from
**Southern
Water**

BR/87/19/PL

Proposal: Change of use of parts of seafront for temporary food & drink outlets & other seaside uses together with associated temporary/portable structures & equipment for use by businesses associated with those outlets.

Site: Various sites along Bognor Regis Promenade, Bognor Regis, BN17 5LF.
BR/87/19/PL

BLOCK PLANS - SHEET 1 OF 2

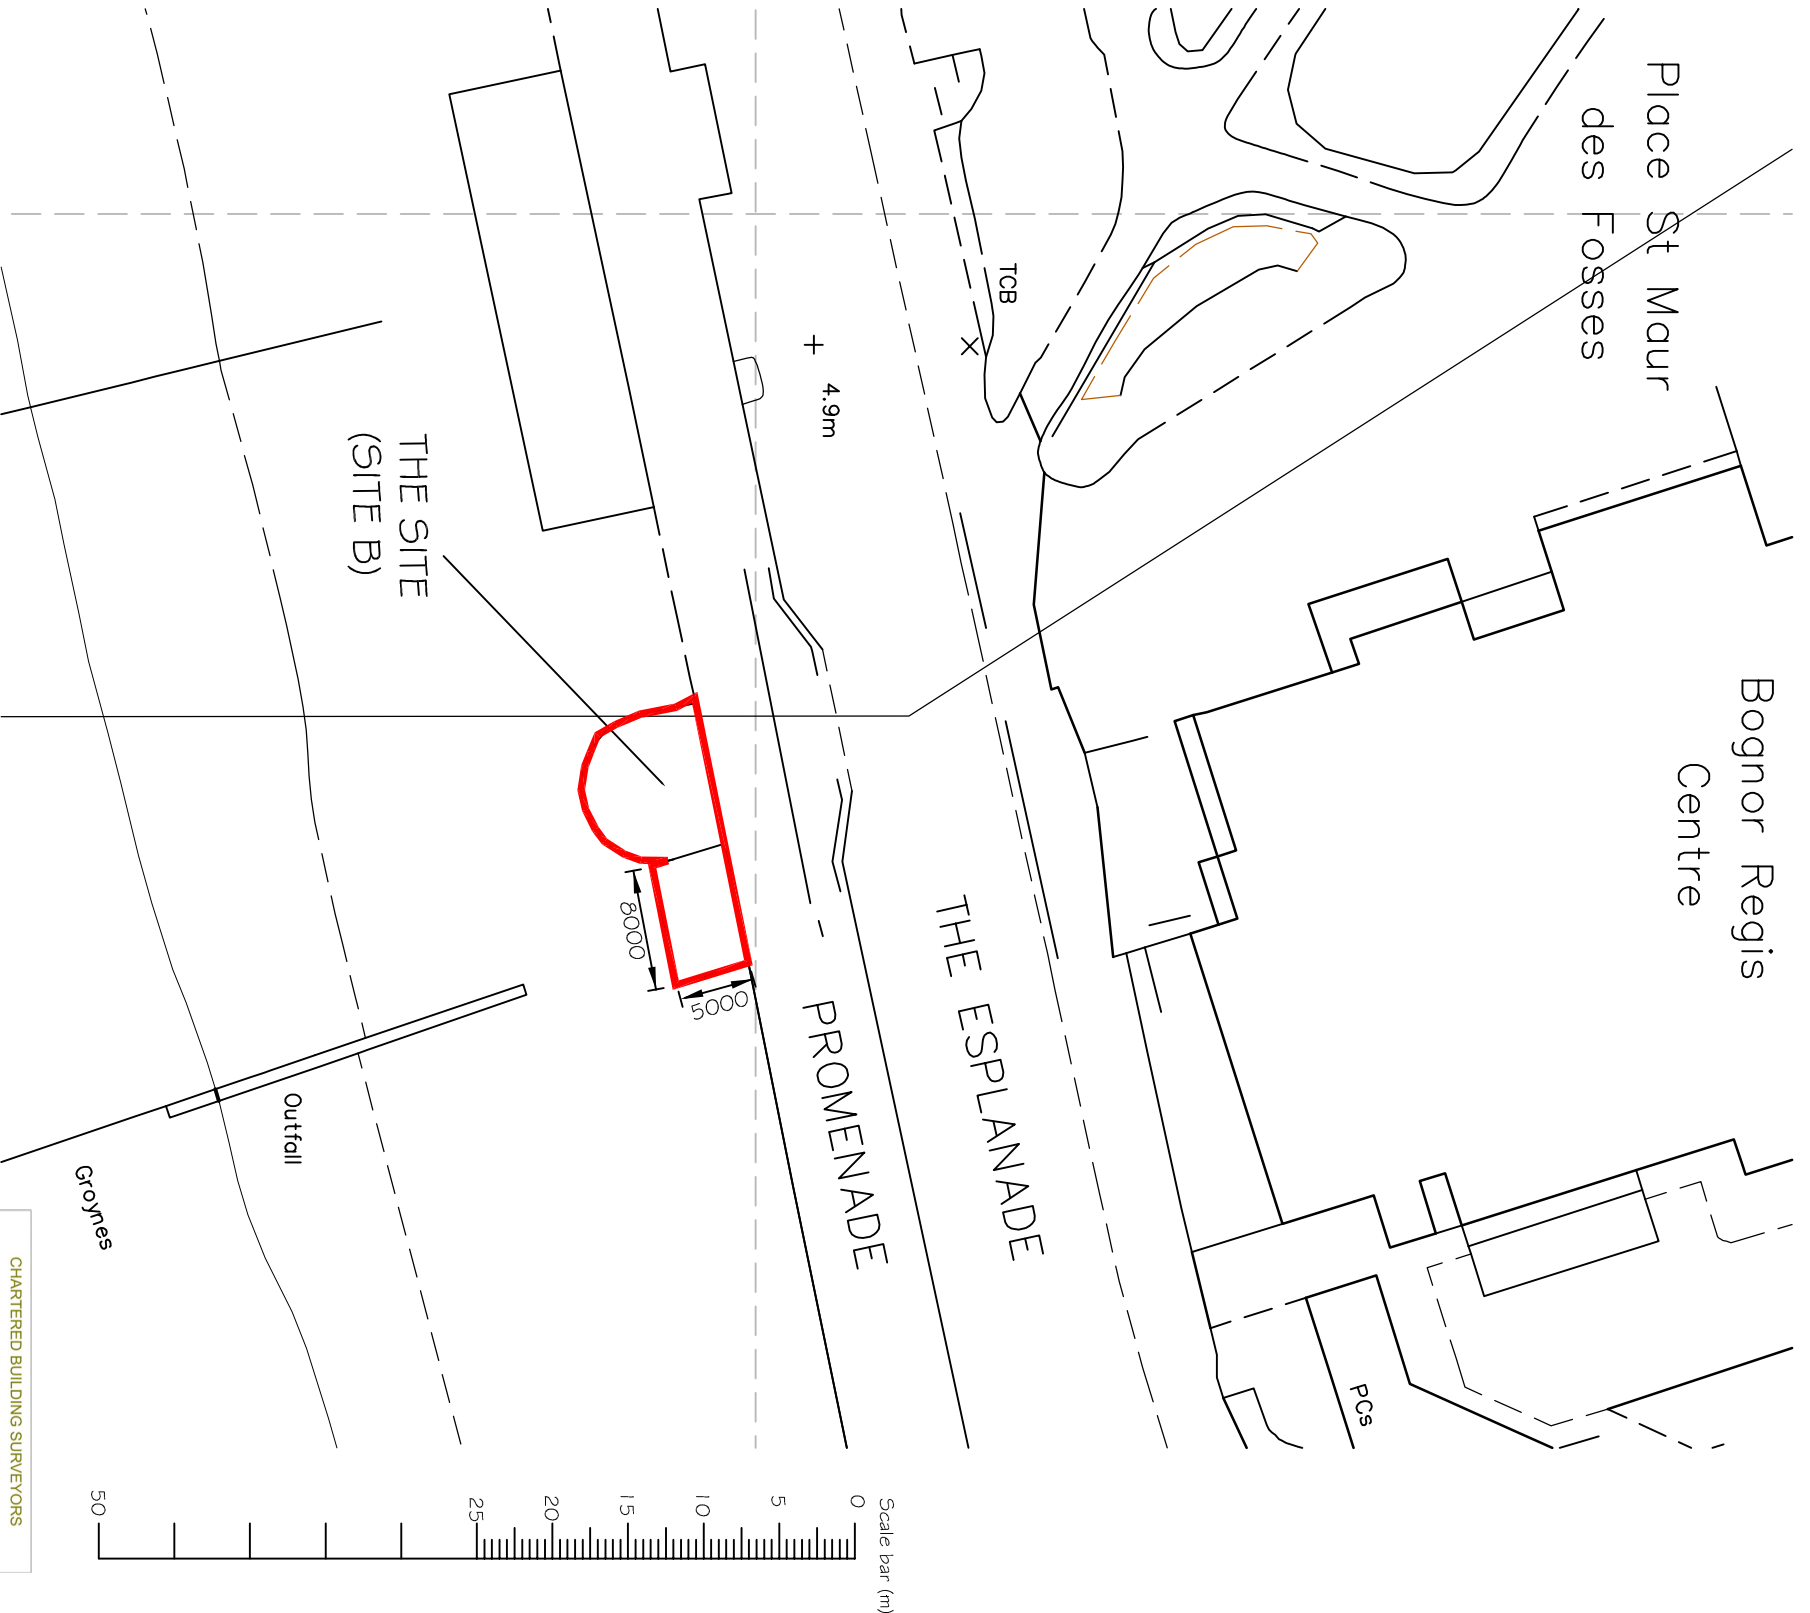
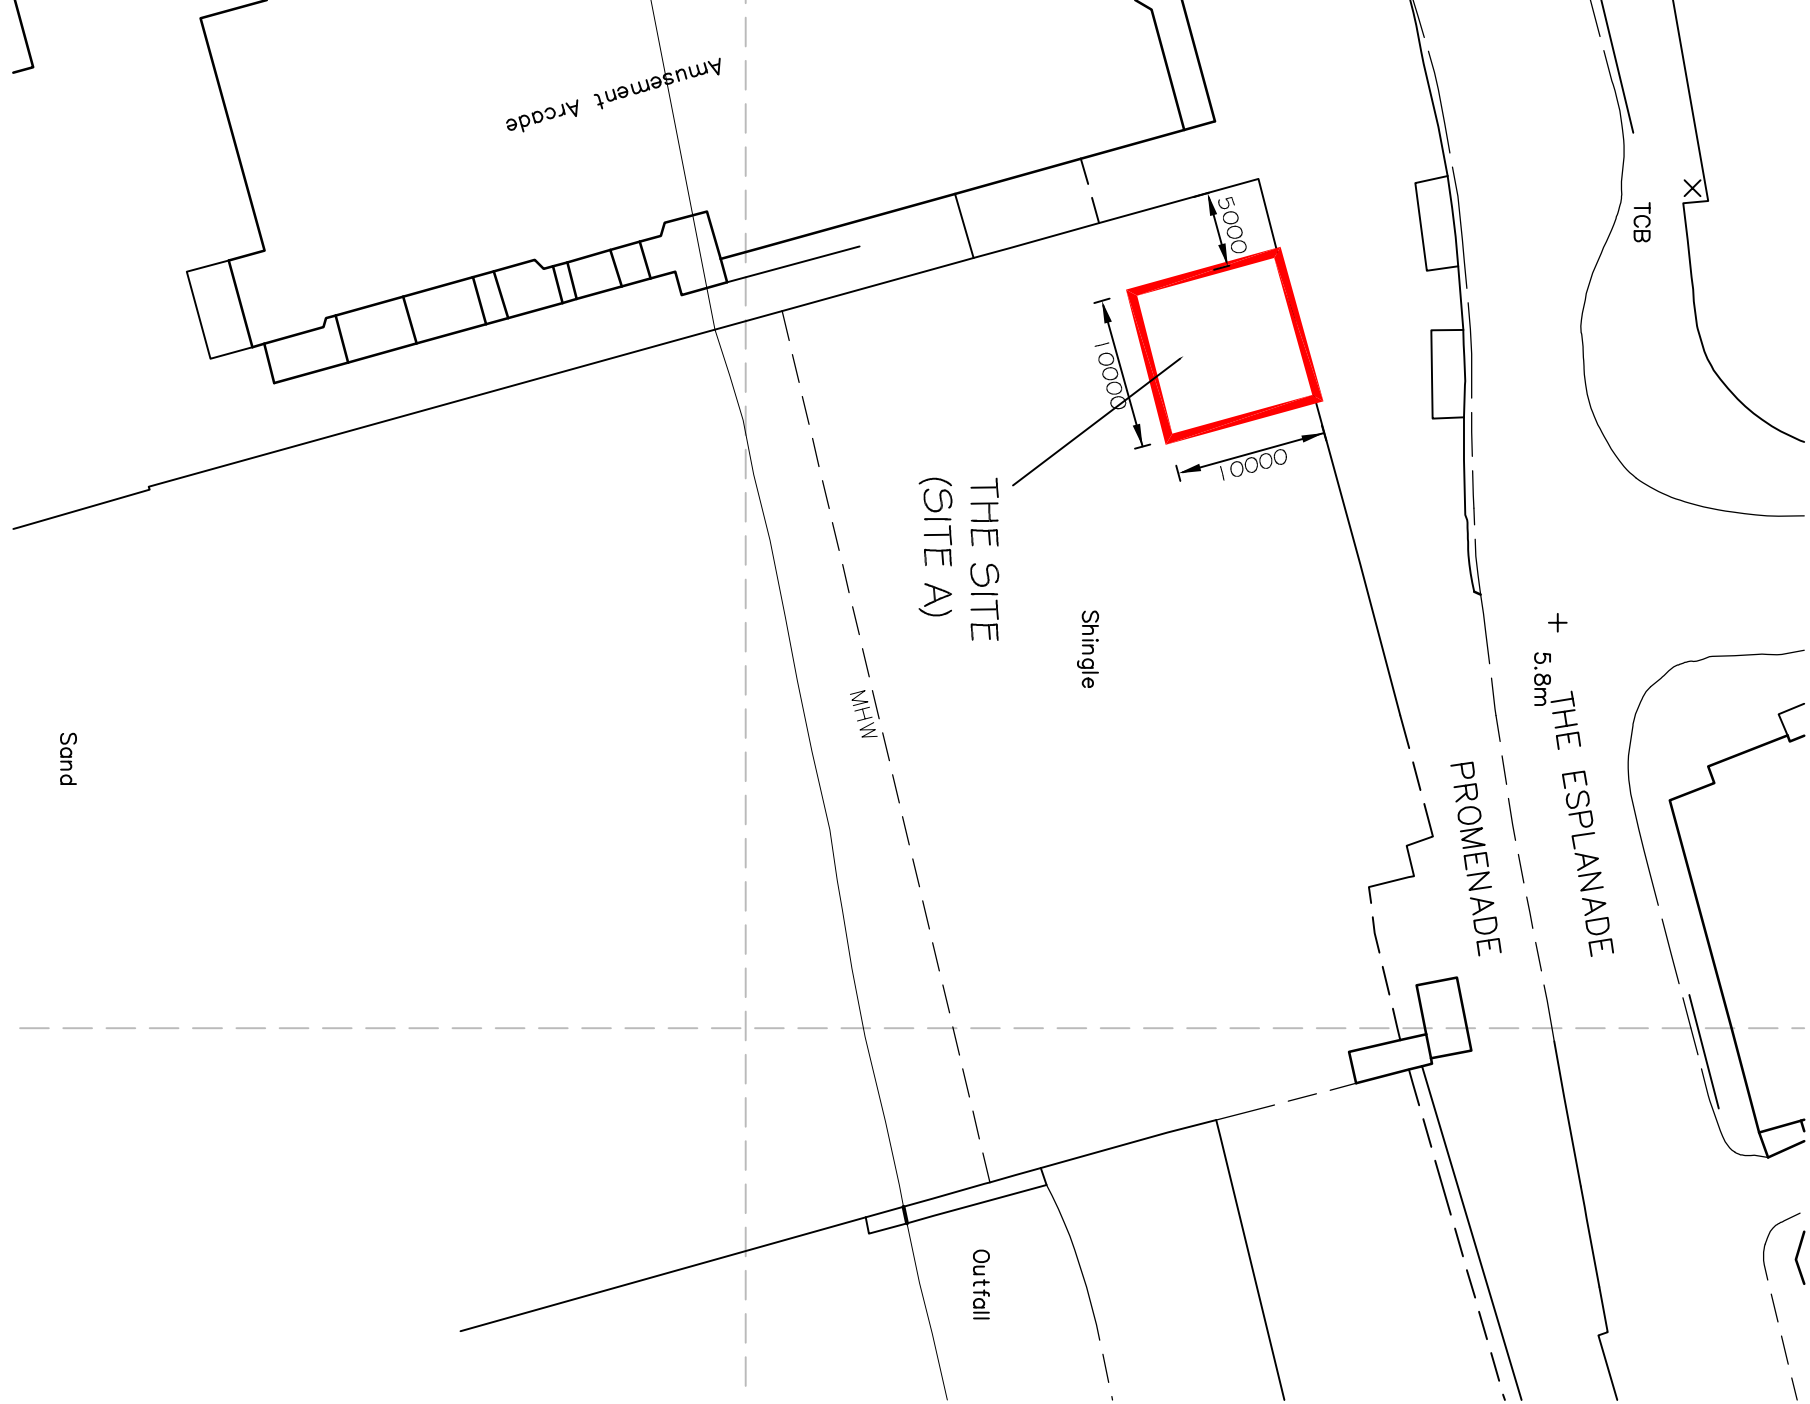
Please find attached a plan of the sewer records showing the approximate position of surface water sewers within the site (site B). The exact position of the surface water sewers must be determined on site by the applicant before the layout of the proposed development is finalised.

- No excavation or new tree planting should be located within 3 metres either side of the external edge of the (300 mm and 375 mm) surface water sewer.
- No excavation or new tree planting should be located within 3.5 metres either side of the external edge of the 675 mm surface water sewer.
- No new soakaways should be located within 5m of a public sewer.
- All existing infrastructure should be protected during the course of construction works.
